Date: 08/20/2025

Re: Framing Issue
Location: Lot 20 Honeycutt Hills (380 Shelby Meadows Angier, NC)
JDS Project No.: RDU2508618
Date of Inspection: 08/20/2025

5 DECK LEDGER CONNECTION DETAIL
SCALE: 3/4"=1'-0"

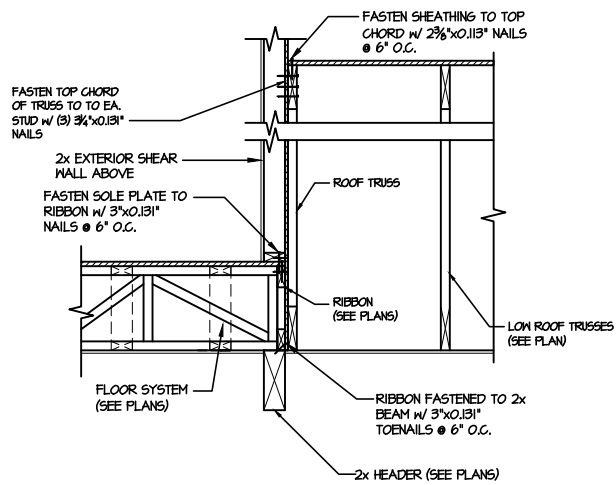
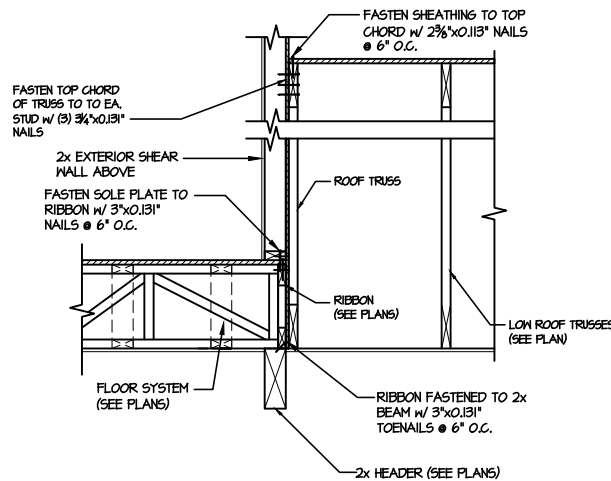
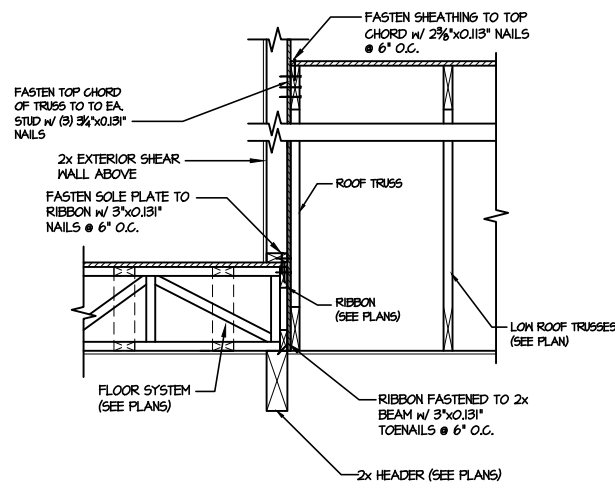
The client requested an evaluation of a ledger issue at the rear porch the plans provided specify a 2x10 ledger, due to clearance issues the client has installed a 2x4 ledger attached with (2) rows of 10d nails spaced at 12"-14" o.c.

Based on our observations and review, the ledger is adequate as installed, ensure the ledger is attached per plan specifications.
